**MP10\_0160 Part 3A Major Project:**

**REDEVELOPMENT OF THE SCOTTISH HOSPITAL SITE,  
2 COOPER STREET (FACING BROWN & STEPHEN ST.S), PADDINGTON, WOOLLAHRA**

**Vincent Sicari**

Heritage Branch

DRAWING No
DA233

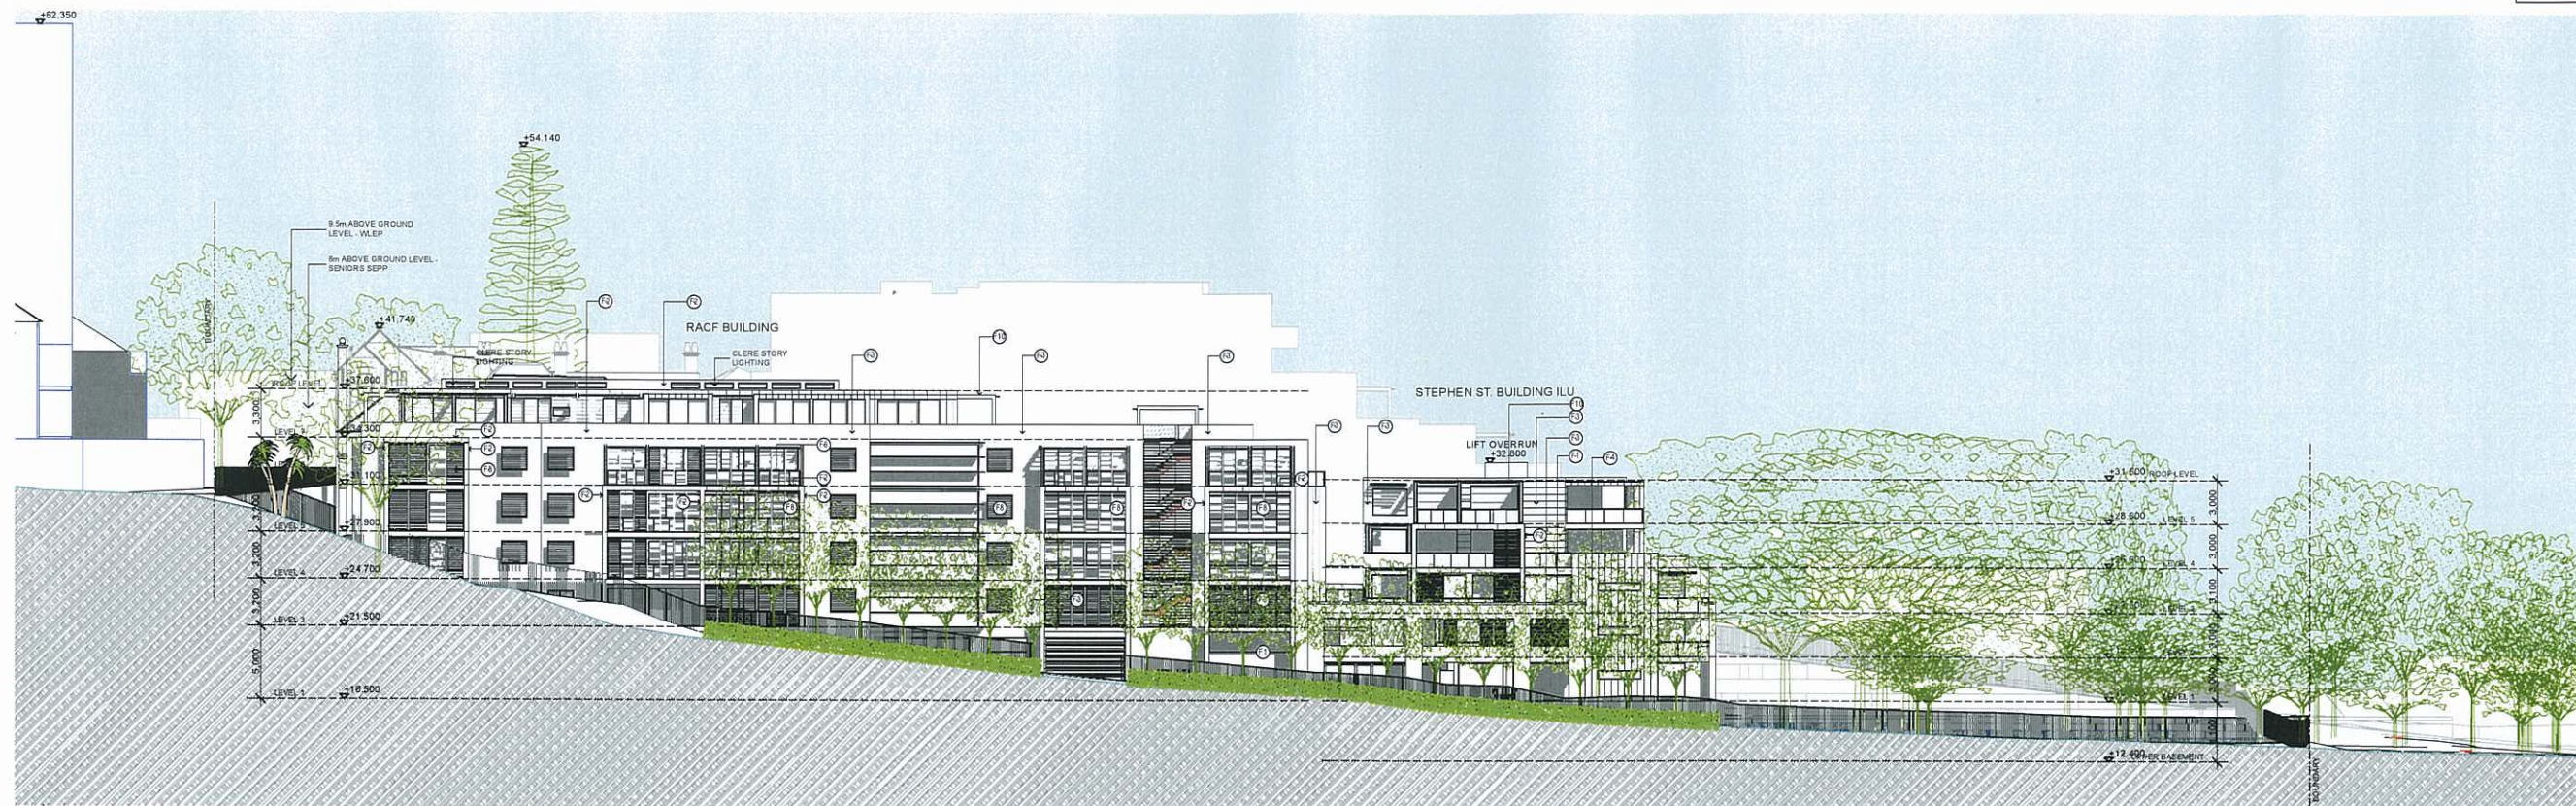
The Branch considers the overall maximum height (at tree canopy level) is too high for this locality and this site. The maximum heights seem to be above the tree canopy level and both new building wings are taller than either ridge or wall heights of the historic house/hospital building. These new heights will result in unduly adverse visual impacts, reduced light levels to areas of its significant garden which in turn will limit what can grow below, and the general health and vigour of remaining significant plants. The Branch recommends adding a condition requiring that heights be reduced by at least one level on both new buildings.
